| Application number: 2026/CLD/91507/E |                                                                                  |
| What is the application for?:        | Certificate of lawfulness for proposed change of use of residential dwelling (Us |
| Address of the site or building:     | 12, South Brook Gardens, Mirfield, WF14 8LS                                      |

| drawing     | PROPOSED PLANS & ELEVATIONS                                              |             |       |

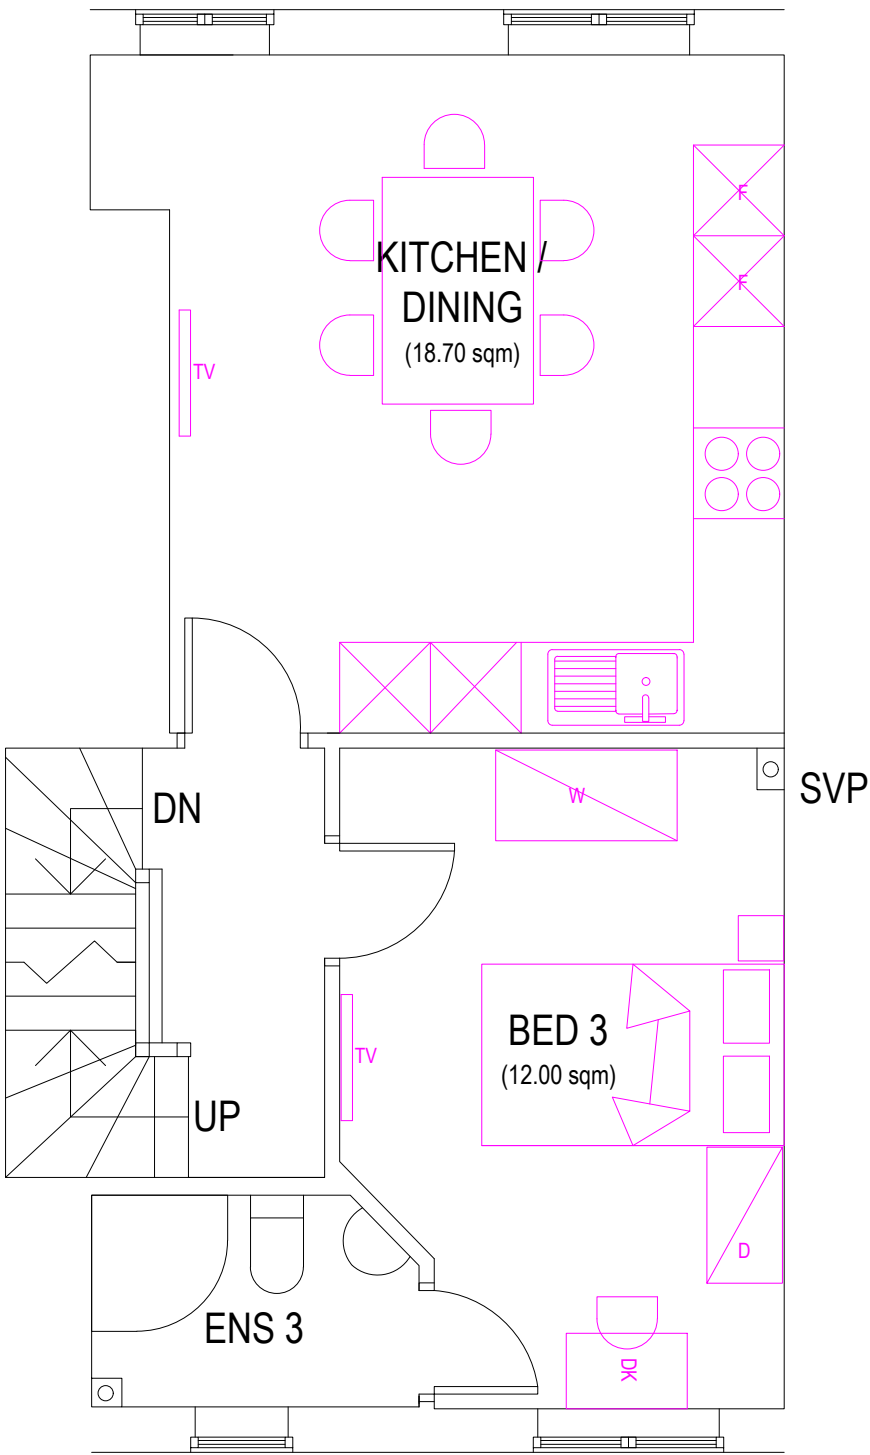
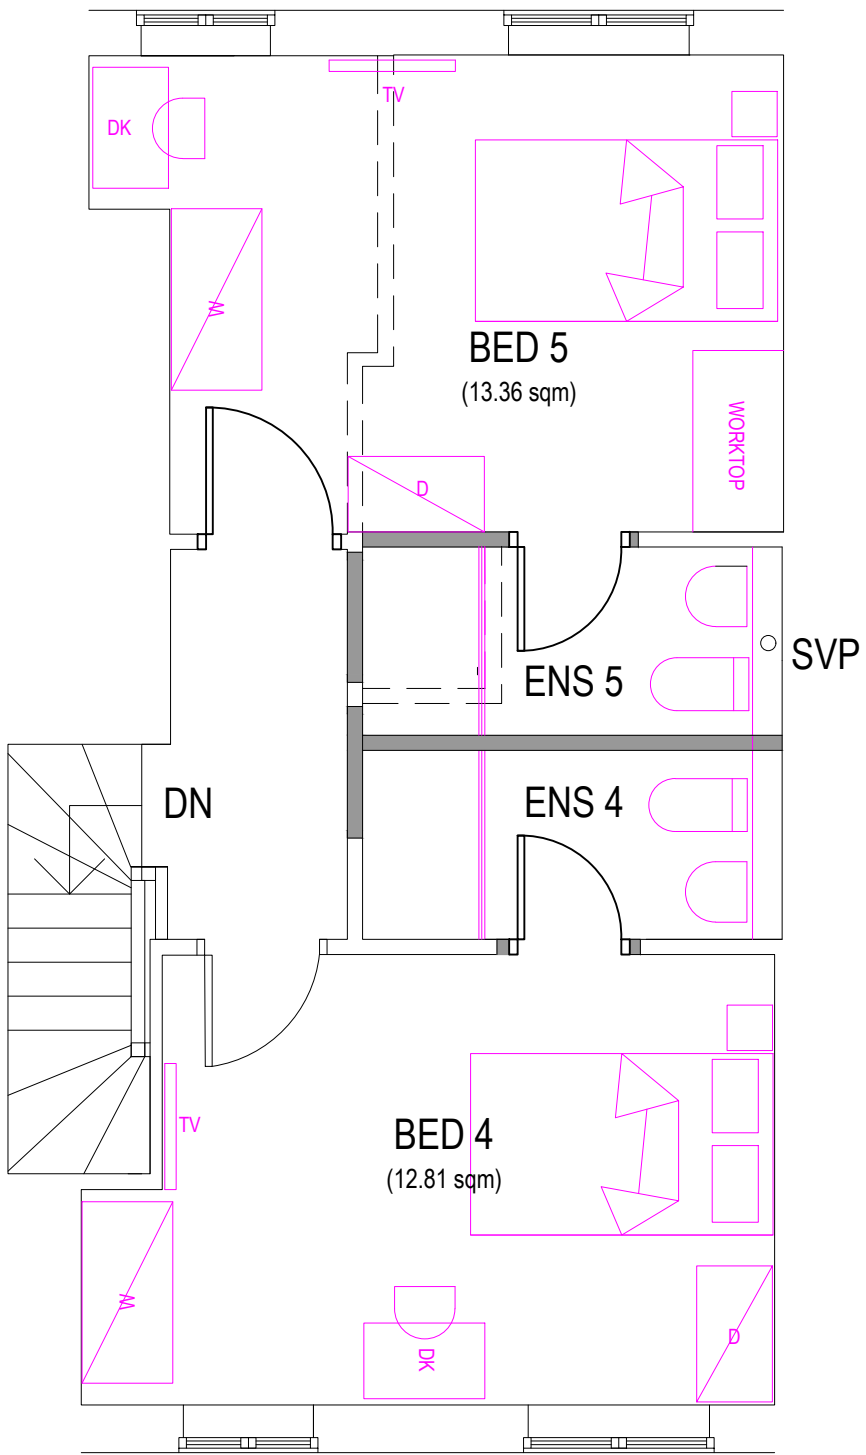
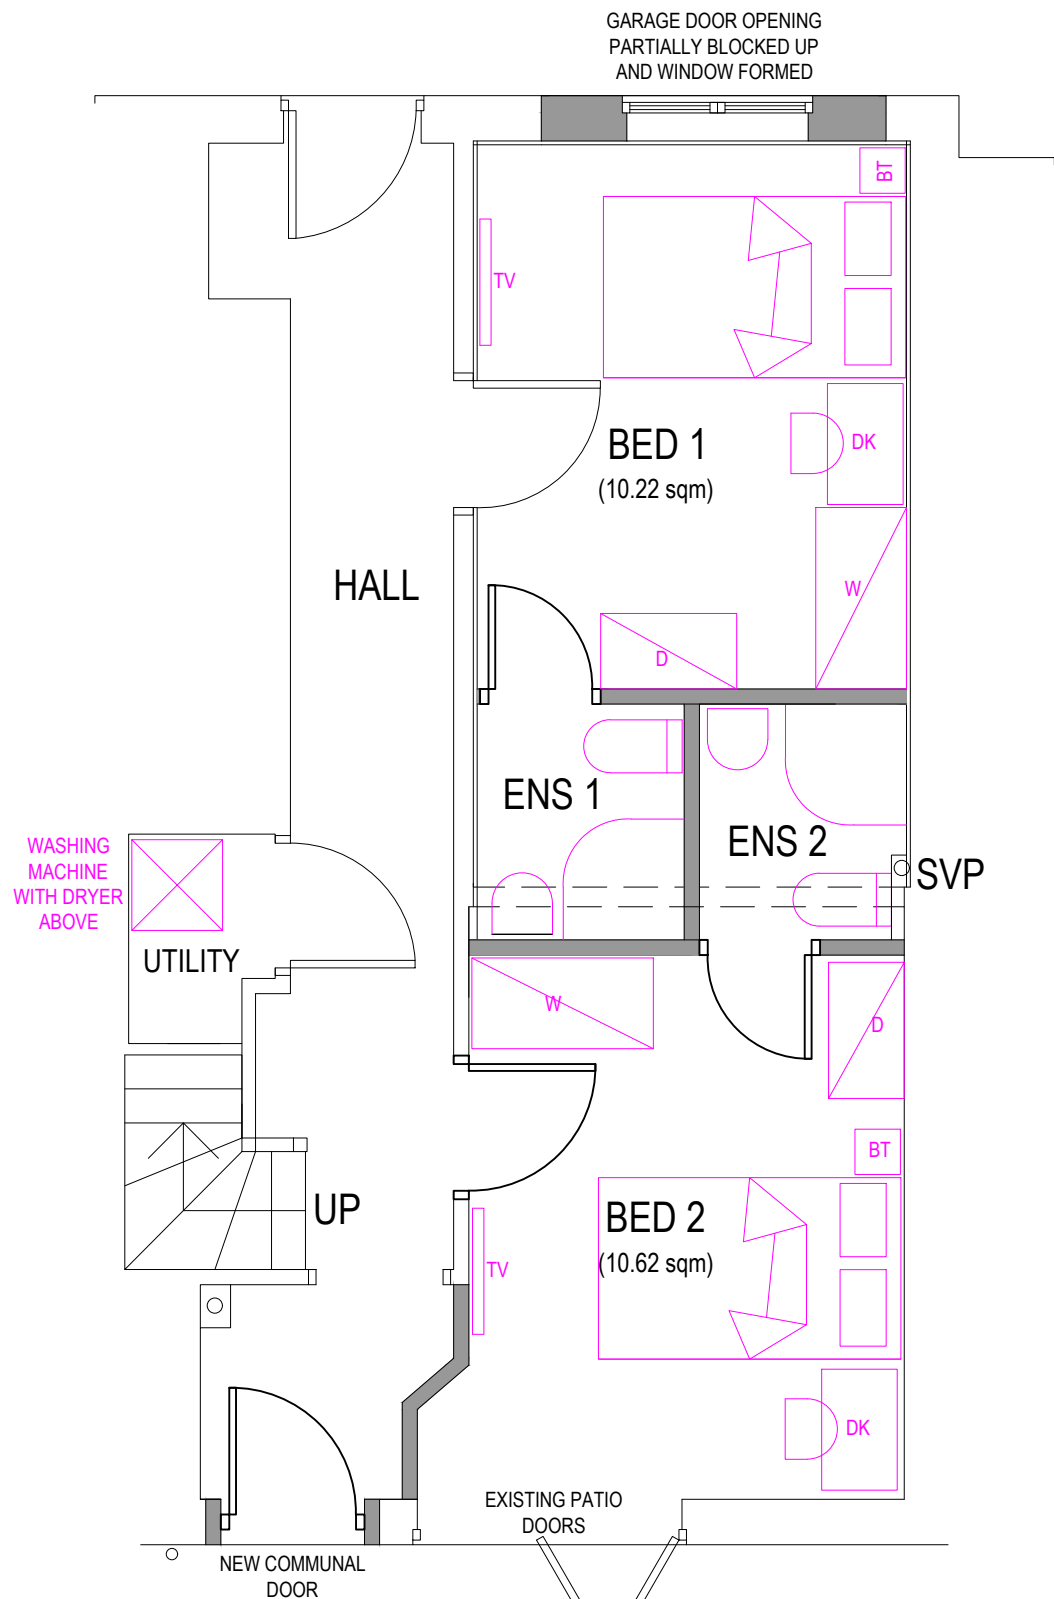
| <p>I am writing to object to the issuance of a Lawful Development Certificate for application reference 2026/CLD/91507/E.</p> <p>The applicant's submitted floor plans indicate 5 double bedrooms and 5 separate bathrooms, creating a layout optimized for a minimum of 7 occupants and in fact up to 10.</p> <p>As occupation by 7 or more unrelated individuals constitutes a Sui Generis use rather than Use Class C4, the development does not meet the criteria set out under Class L of the GPDO, and a full application for planning permission is required.</p> |     |
